**Subject: 185 Fore Street
Final Level III Site Plan and Subdivision Application
Letter of Response #3**

COMMENTS FROM DAVID SENUS, WOODARD & CURRAN DATED 02-26-15

E1.01

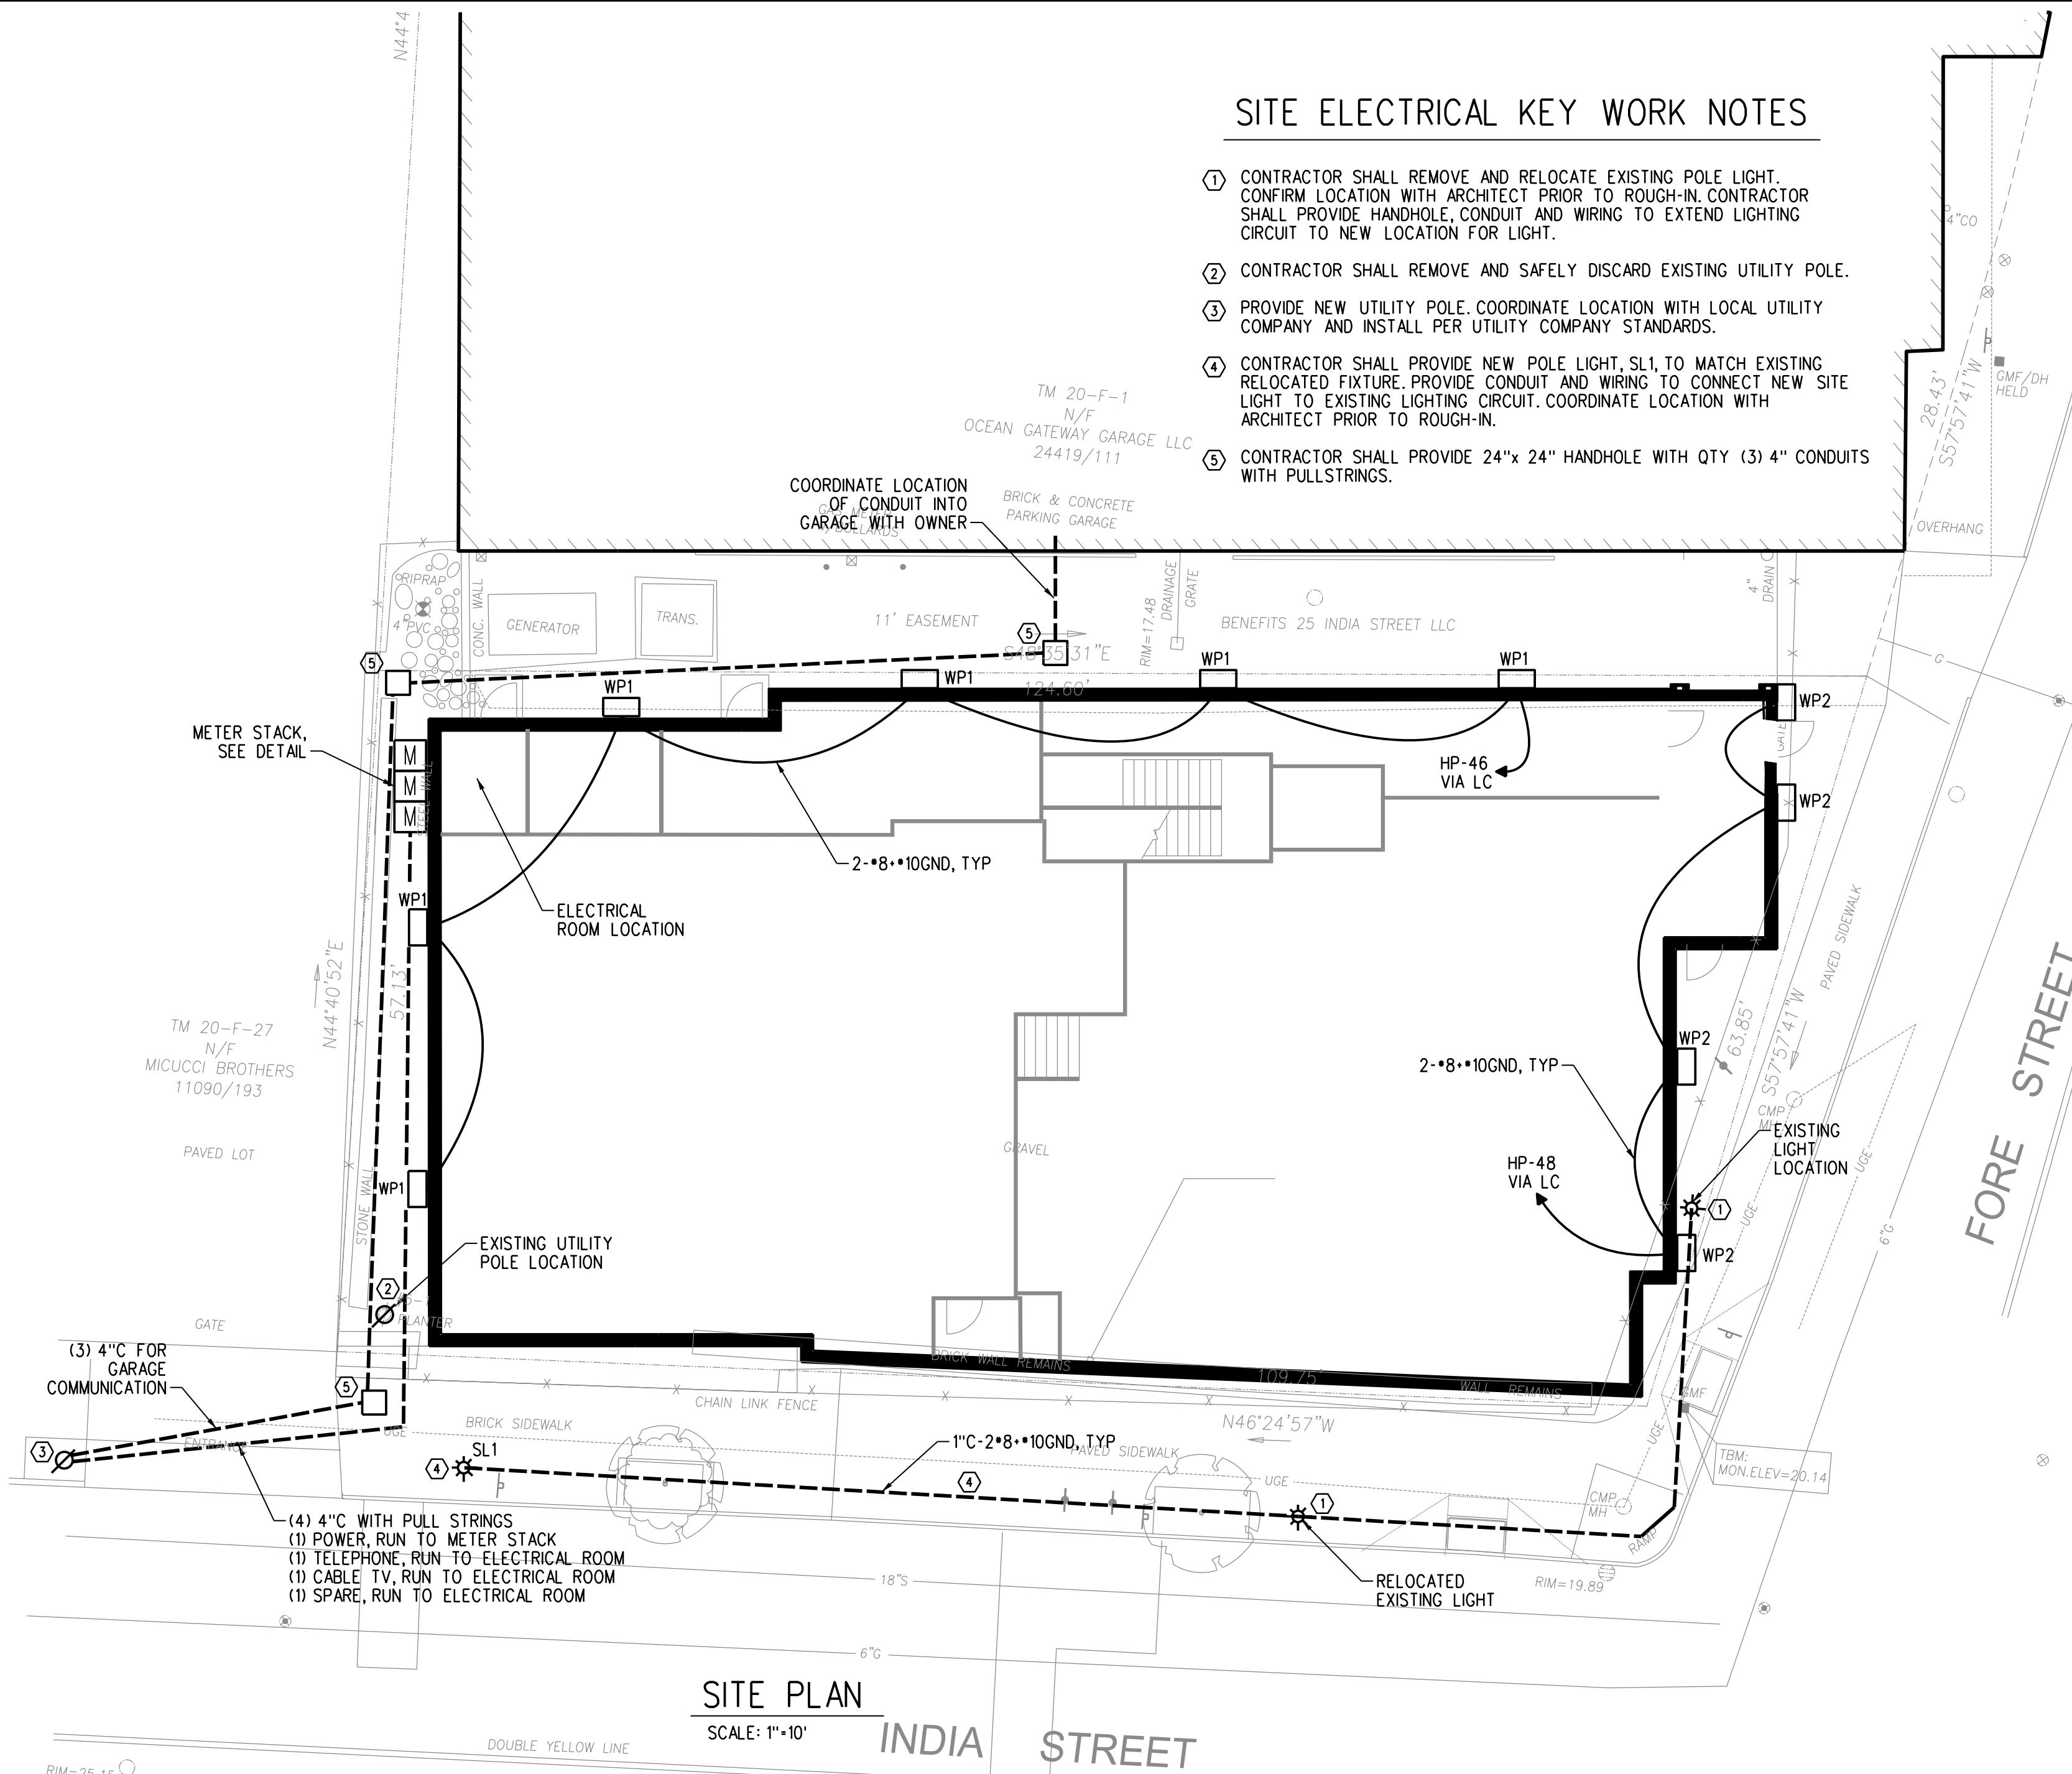
Sheet E1.01 shows an eight inch roof connection to the 18" sewer in the street. Sheet C4.0 shows this connection into a catchbasin. Please delete connection on Sheet E1.01.

Sheet E1.01 has been revised as requested. The revised sheet is included in the attached plan set.
